Appendix A – Response to DPHI RFI

Table 1 Response to matters raised by Department of Planning, Housing and Infrastructure (DPHI)

4 HEIGHT PLANE DIAGRAM_SOUTH WEST

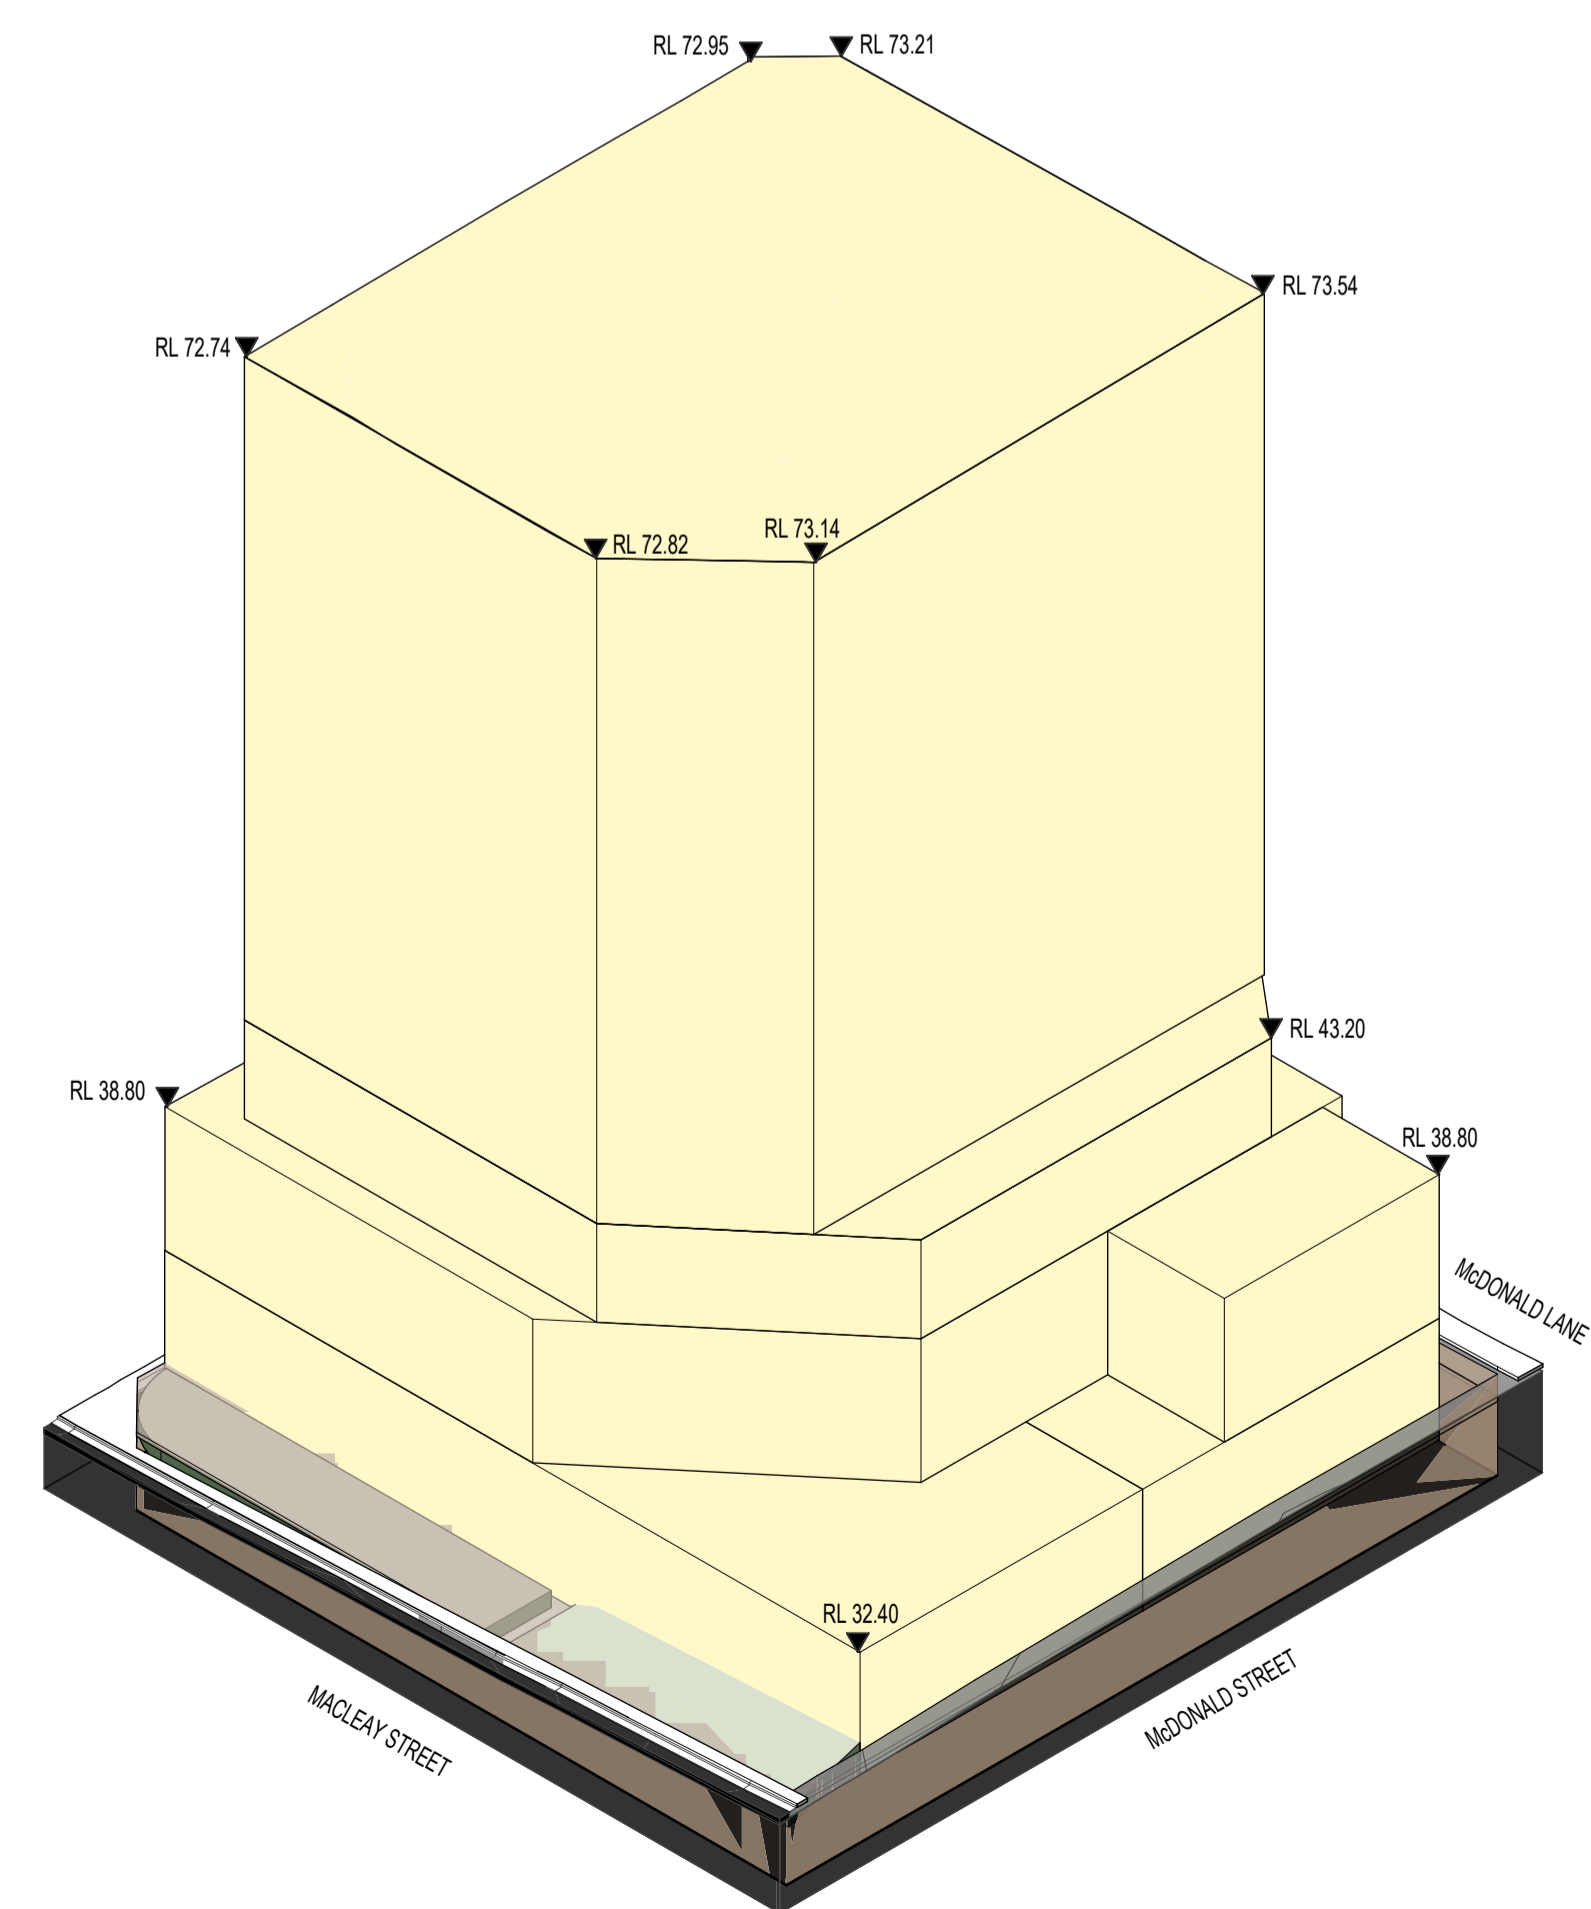
(b) Indicate the location and area of deep soil zones on the site plan.	The deep soil zone is proposed to be located along McDonald Lane and has been depicted in the updated Site Plan at Appendix B.	Appendix B
(c) Align the basement setbacks between the site plans and elevations. Specifically, the 2m eastern setback and the 3.8m western setback to the basement depicted on the site plan are not accurately depicted on the elevations.	The envelope elevation plans have been updated to show the basement setbacks at Appendix B.	Appendix B
(d) Detail the street names/frontages on the height plan diagrams.	Amended height plane diagrams containing street names have been provided at Appendix B.	Appendix B
